March 25, 2011

Re: Munjoy Commons, Emerson School
Pricing Request #29
Roof Hatch Options

**7** SECTION @ FIRE ESCAPE STAIR

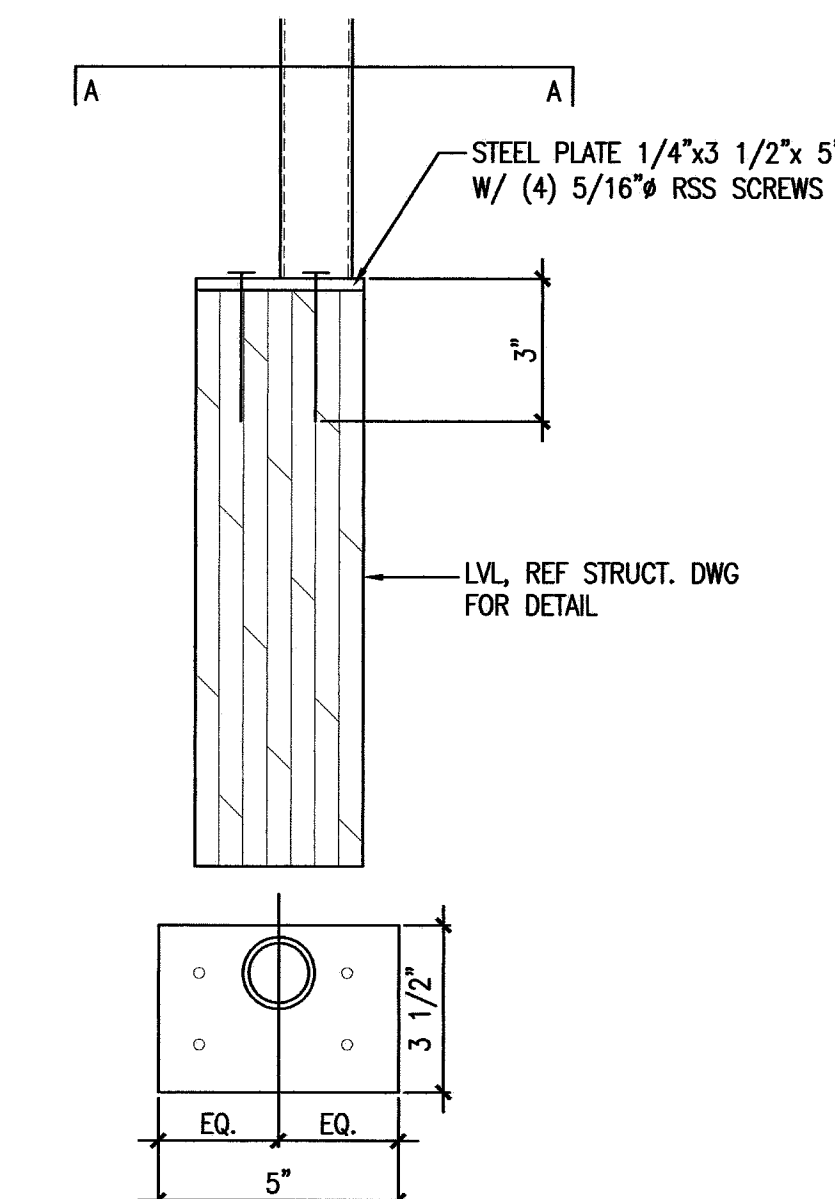
Option 1. Install Bilco Type F-50T roof hatch and wall-mounted ladder. 1/SKA-30

- Coordinate MEP and insulation systems around the roof hatch location;
- Remove a section of soffit along the steel truss, frame new wood-stud wall and wood infill at the steel truss to support the wall-mounted steel ladder;

- Install sistered roof rafters. Install 2x10, sistered to the rafter at both sides of the roof hatch. The rafters are to bear on the steel trusses at each end of the fire escape stairs;

- Head off cut rafters with (2) 2x10 full length of the roof hatch with Simpson double hangers at the ends onto sistered rafters;
- Re-support and head off cut ceiling joists with (2) 2x6 the width of the opening;

- Infill between rafters and joists with 2x framing to support GWB finishes;
- Complete GWB from roof hatch to suspended GWB ceiling;
- Install roof hatch (orient hatch opposite as shown so that the handle is above the ladder) with LadderUP® Safety Post (LU-1) and ladder based on IMC 2003 requirements;

- Paint finishes according to specifications. Do not paint primed ladder rungs.
